Rezoning Transportation Analysis

Petition Number: 2024-024

Date	Description
3-27-24	First Review (TM)
04-24-24	Second Review (TM)
08-27-24	Third Review (TM)

# RZ-1.0

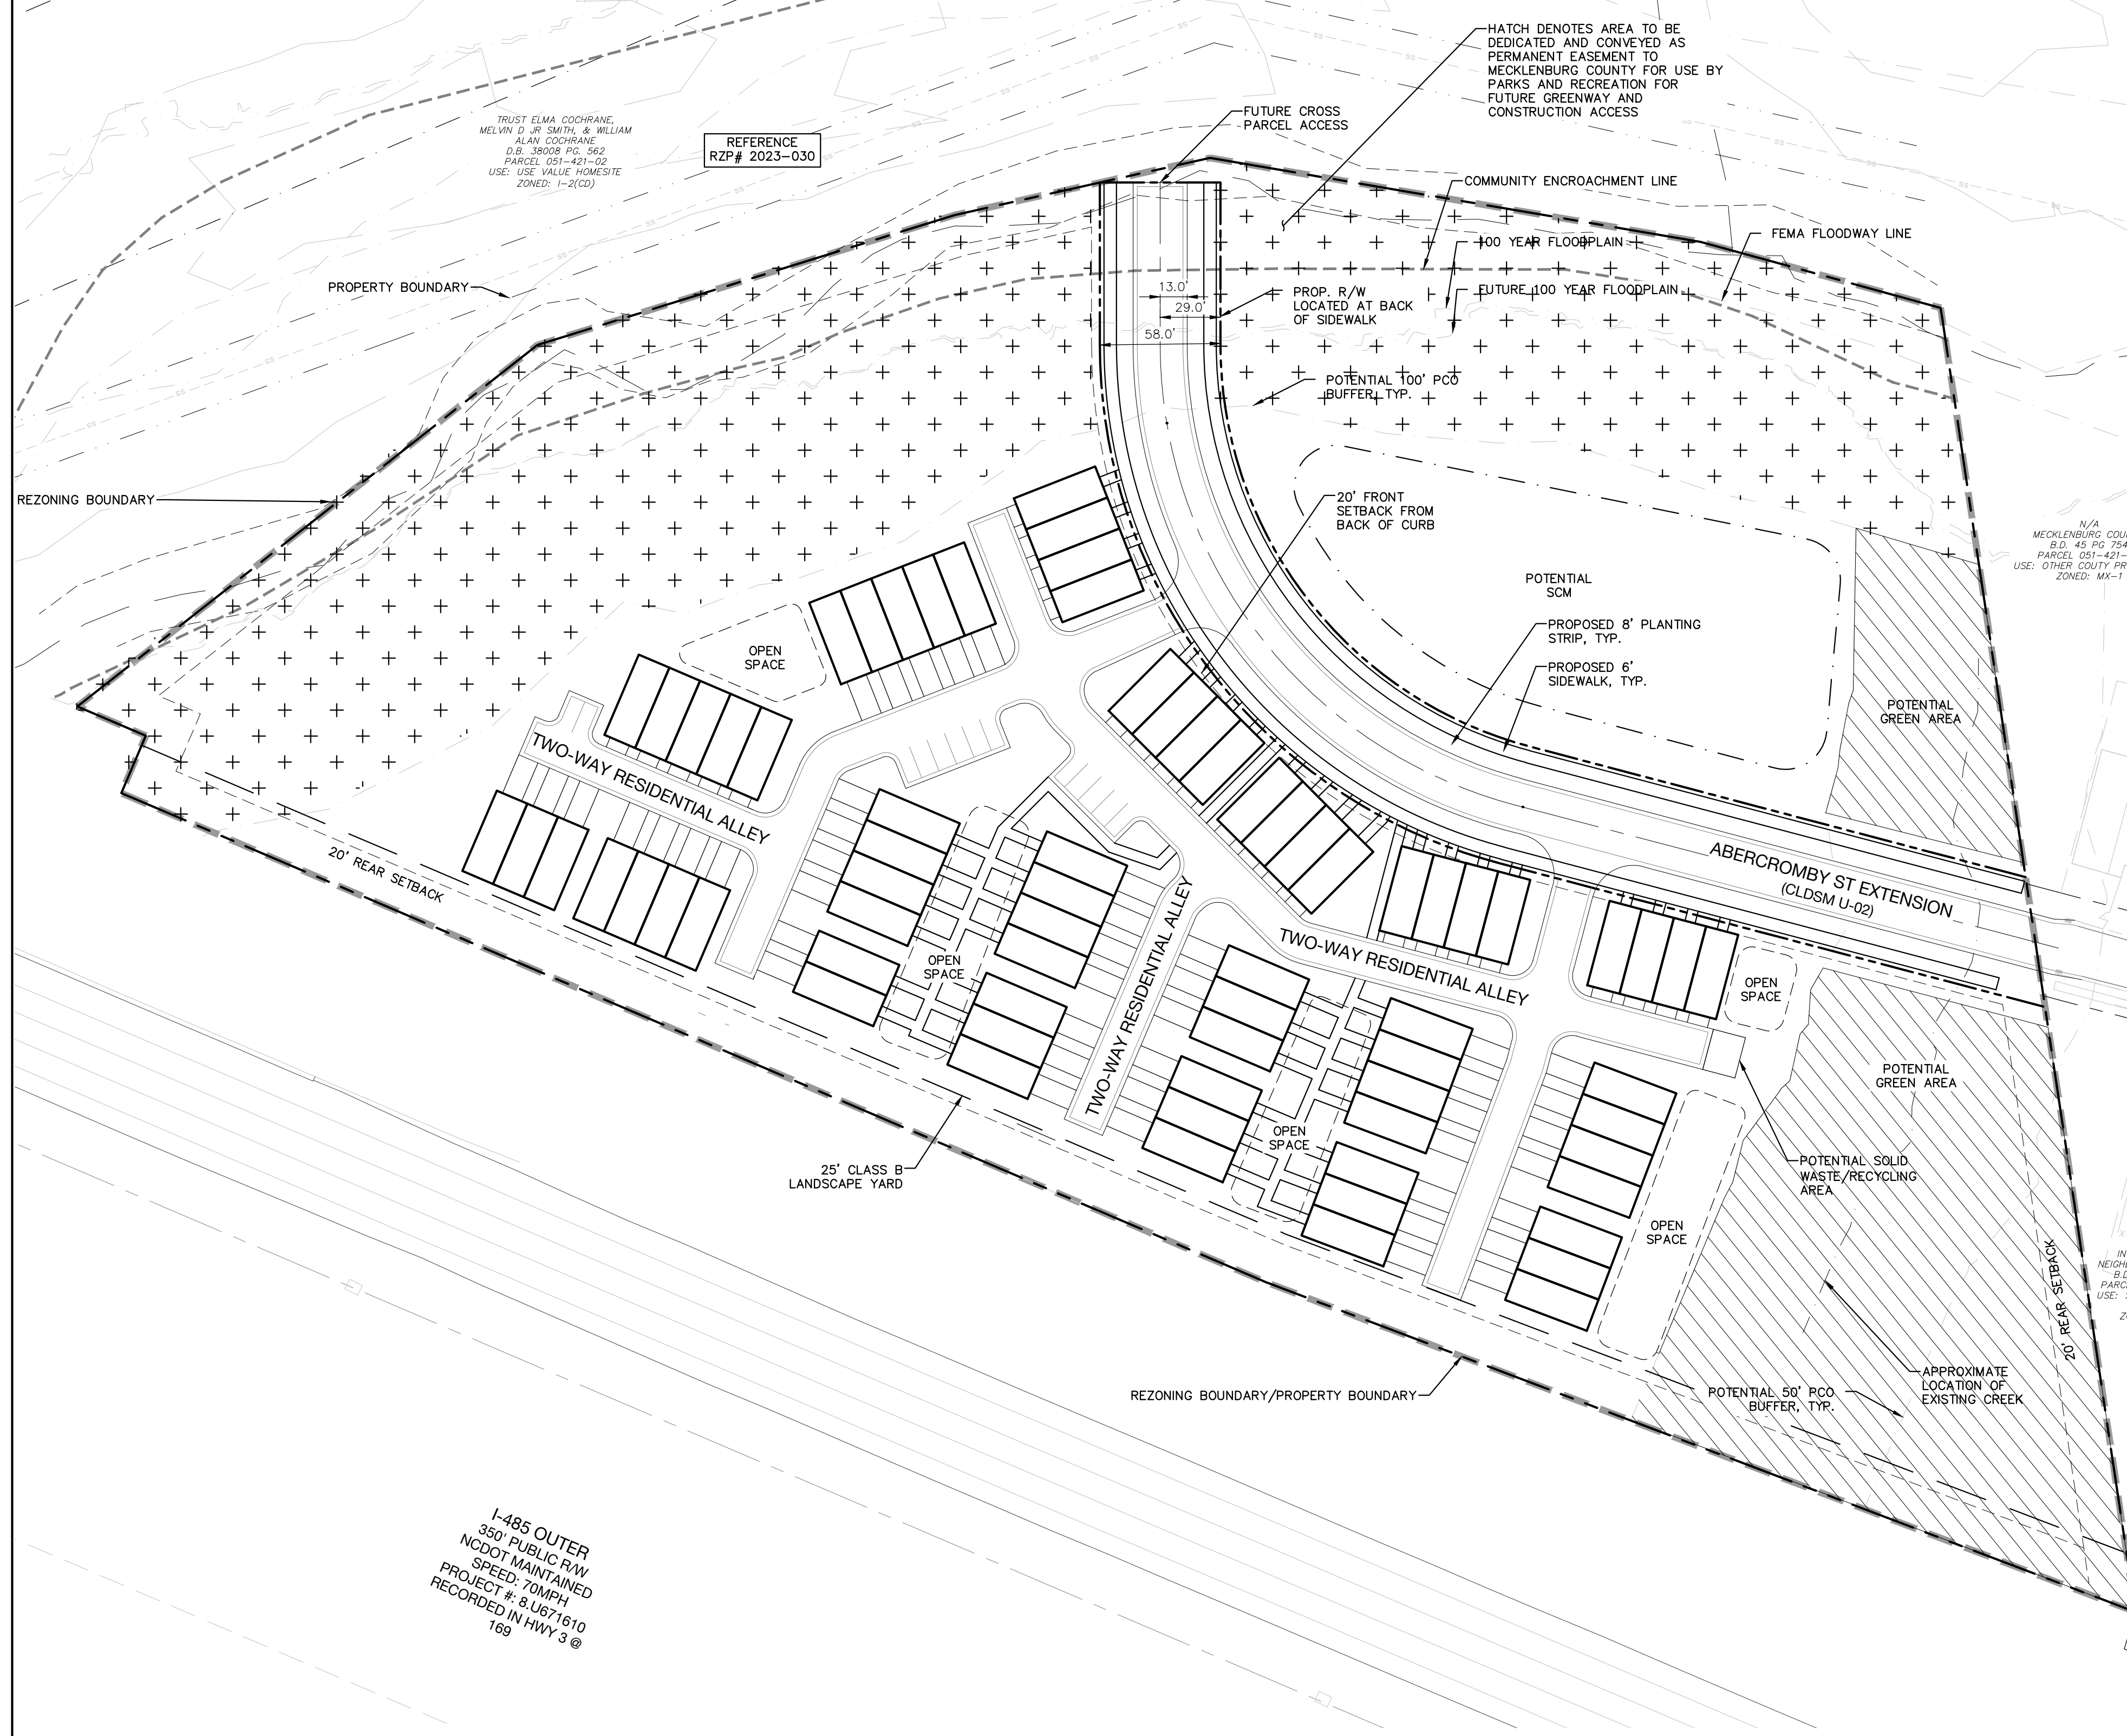
- a. ~~Abercromby Street:~~ Location of future back of curb and gutter is to be located at 15 feet from roadway centerline per CLDSM U-02B.

Label and dimension the curb and gutter from the centerline for each road on the site plan.

5. **Outstanding Issue from 3-27-24:** N-2 requires that the roadway be constructed to a residential wide roadway cross section (CLDSM U-03) Per UDO. To remain consistent, CDOT request that this roadway remains as proposed, a residential medium (CLDSM U-02) matching the cross section of approved rezoning 2023-030 and that additional onsite parking stalls are added to the southeastern portion of the site in lieu of providing the on street parking that is provided with a U-03 roadway cross section. Revise site plan and conditional notes to commit to installing parking stalls.

Clarifying comment 04-24-24: Roadway cross section is called out as USDG U-02. Please revise all reference to roadway standard cross section to be CLDSM U-02.
